Tel: 01903 737756
Email: planning@arun.gov.uk
www.arun.gov.uk/planning
Please ask for: Amy Anderson
Email: amy.anderson@terraquest.co.uk
Telephone: 0121 234 1390
Our Ref: FP/184/25/HH
Your Ref:
Date: 3rd December 2025

Application for Planning Permission for Works or Extension to a Dwelling

Development: Garage conversion, porch infill and external alterations.
Location: 32 Normans Drive Felpham PO22 8LW

Proposed Elevations

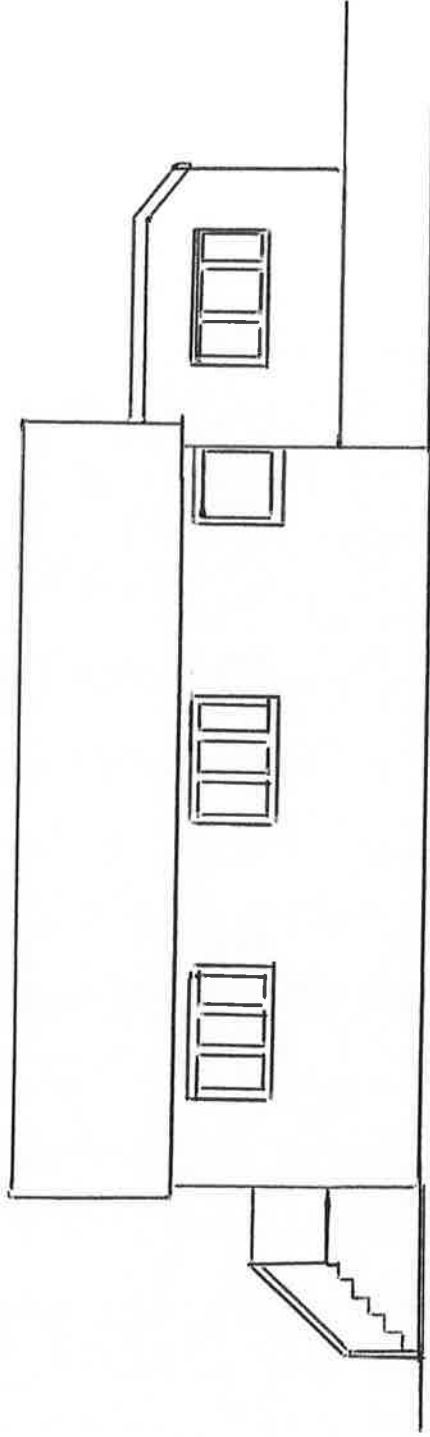
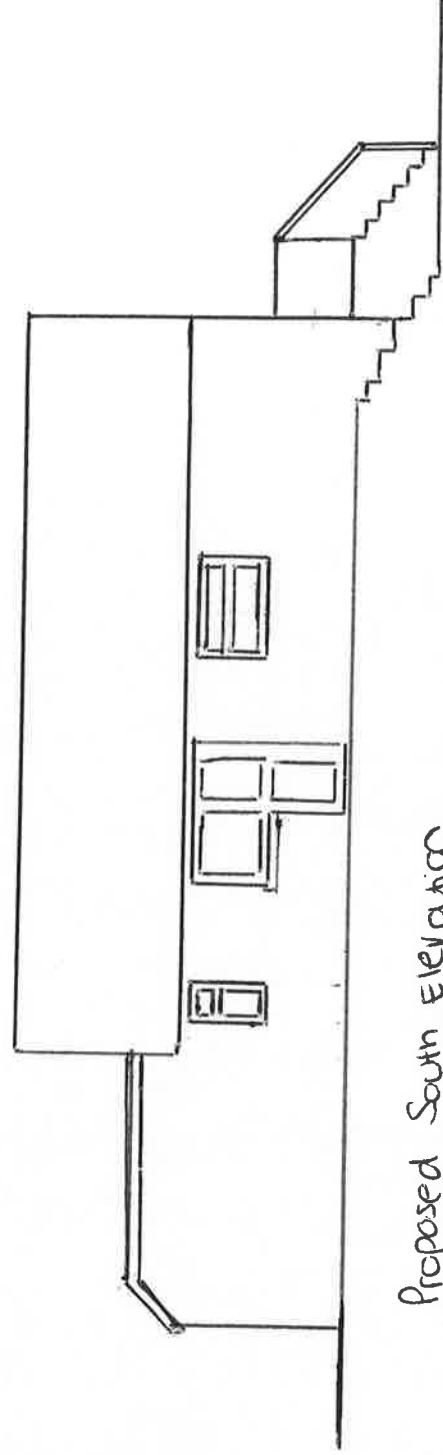
The Elevations need to show any steps/foundations/etc in context to the dwelling.
